TOWN AND COUNTRY PLANNING ACT 1990 SECTION 73 MODIFICATION

Reference: H14-0077-26 **Date of Decision:** 20th March 2026
Applicant: Remway Design
Middledene House
Surfleet Road
Pinchbeck
Spalding
PE11 4AG
Location: 3 Penway Drive Pinchbeck Spalding
Description: Extensions and Alterations - Approved under H14-0931-19. Modification of Condition 2 to allow amendments to previously approved plans

Proposed Block Plan  
1 : 250

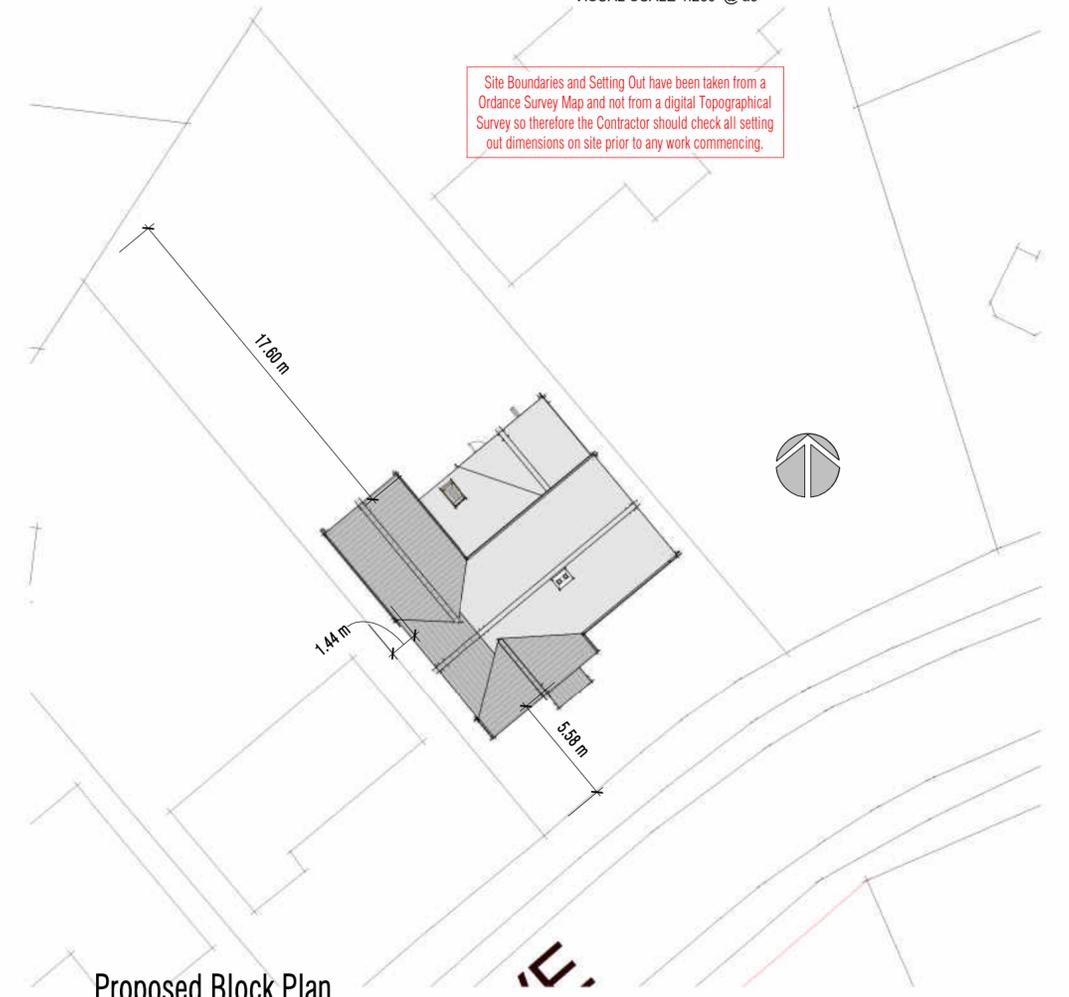
- 2 The proposed rear extension would significantly restrict light entering the neighbouring property to the west, due to its significant scale and positioning close to the boundary. This would therefore reduce the amenity of the occupants of 5 Penway Drive to an unacceptable degree, particularly given that the effected window would serve a primary habitable room.
